From: Kate Giddings
Sent: 08 May 2019 15:43
To: Charlotte Easton
Cc: Planning.Responses; Anna Appleton
Subject: WA/23/19/DOC - Fairmead Farm Land, Binsted Lane, Arundel, BN18 0LQ

In relation to the above, the document supplied is not sufficient for this department to recommend discharge of condition 6 – external lighting.

RA / 674 / 100 D

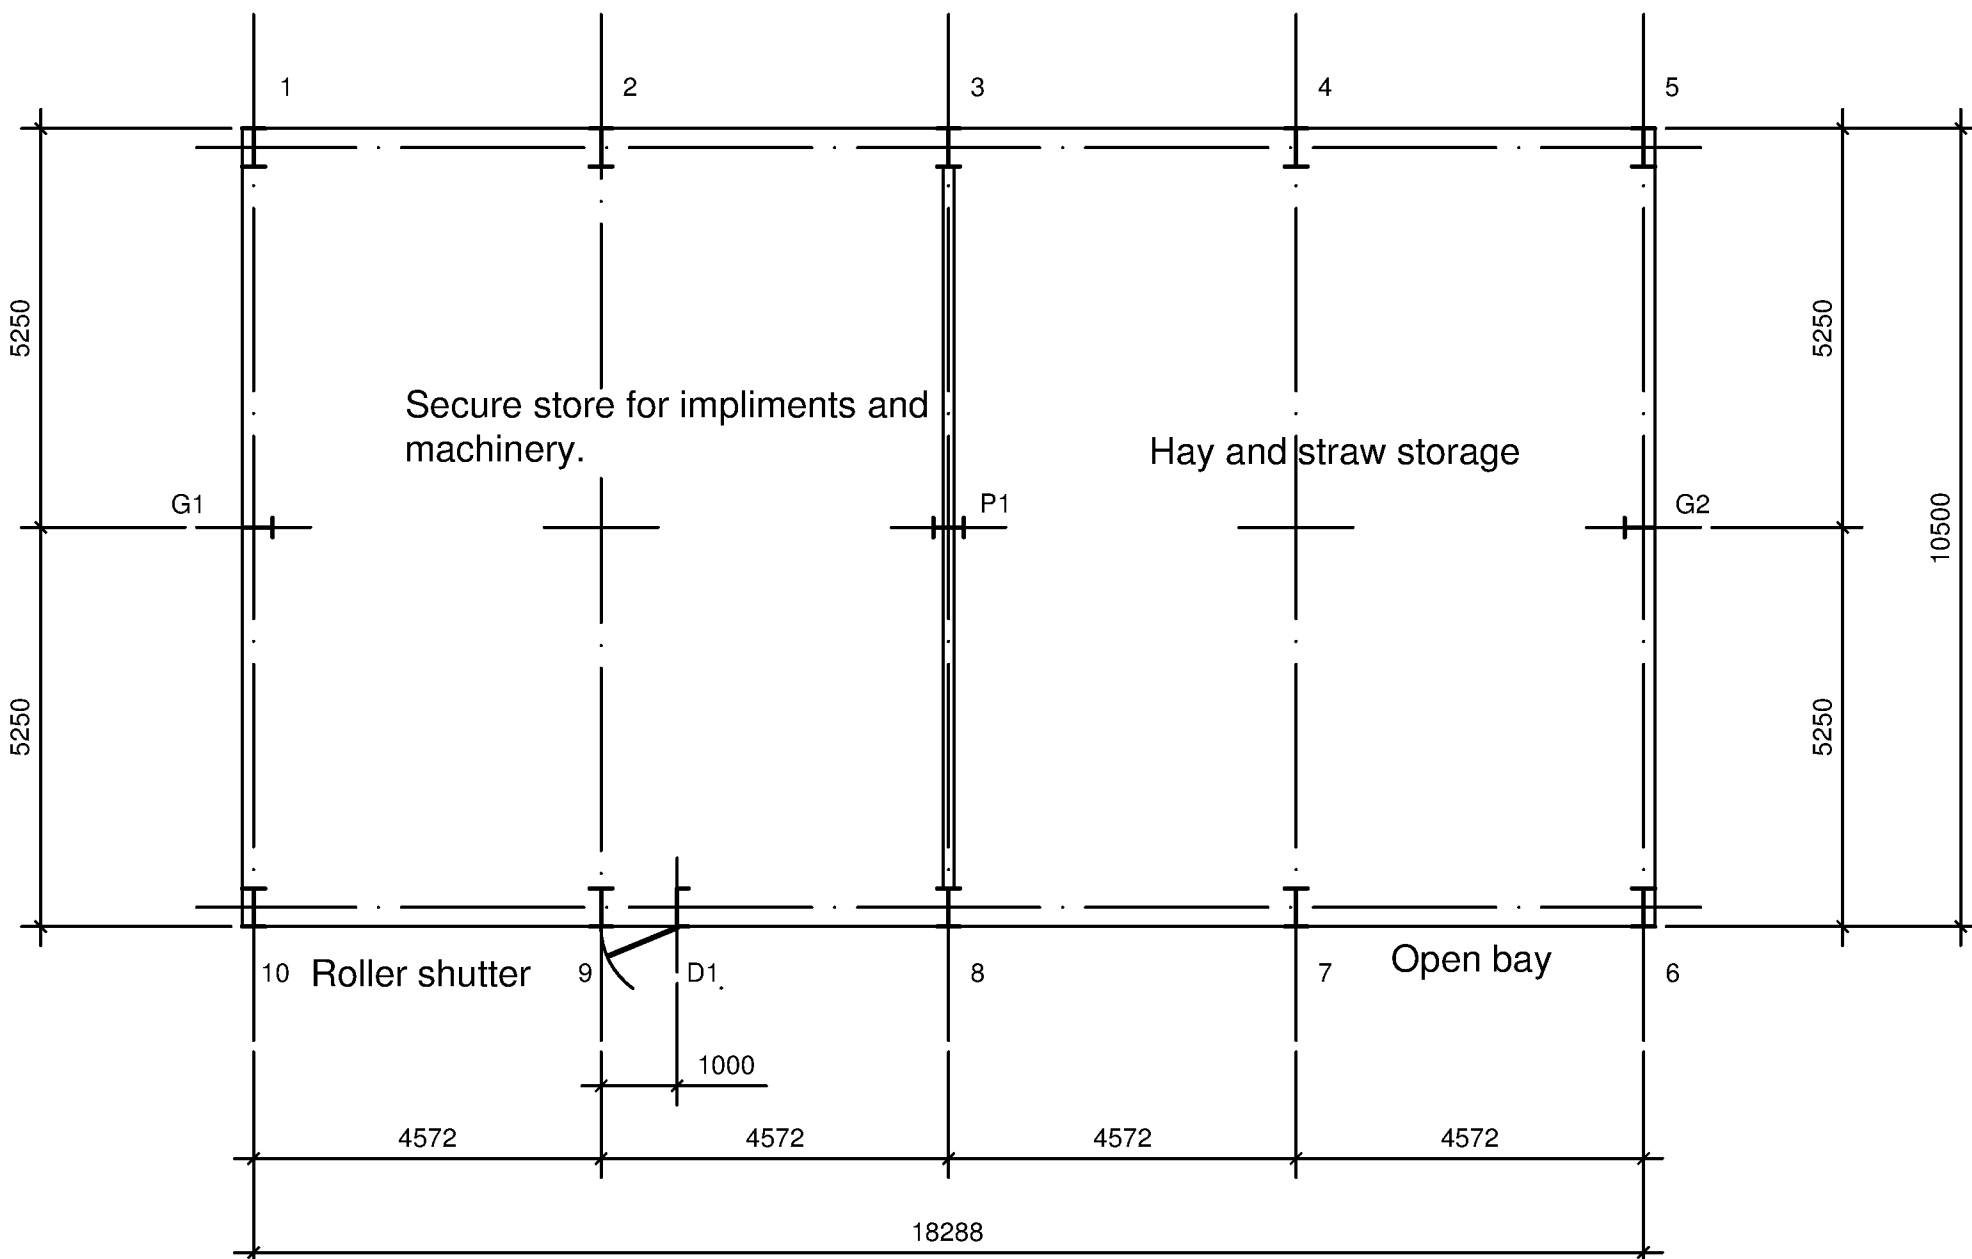
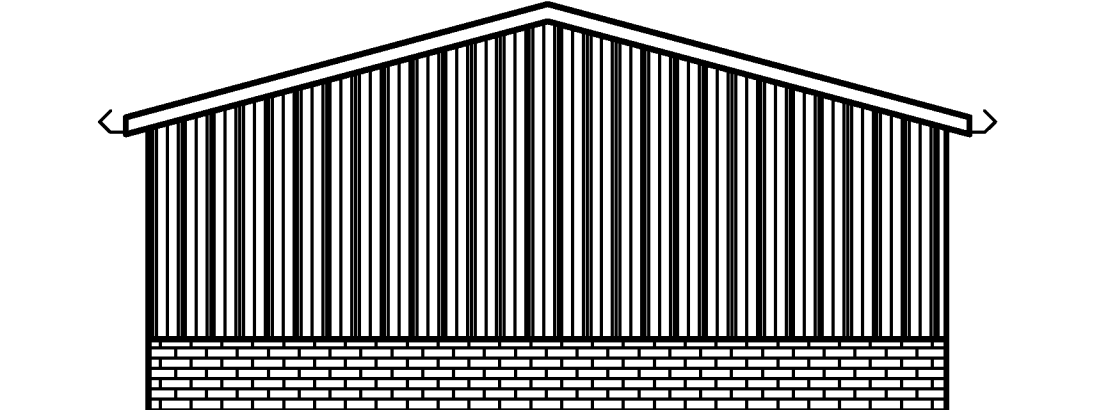
For clarity, the condition requires details on the type of appliance, the height and position of fitting, illumination levels and light spillage. There should also be details regarding the potential impact to bats, however this is not something which can be assessed by this Department.
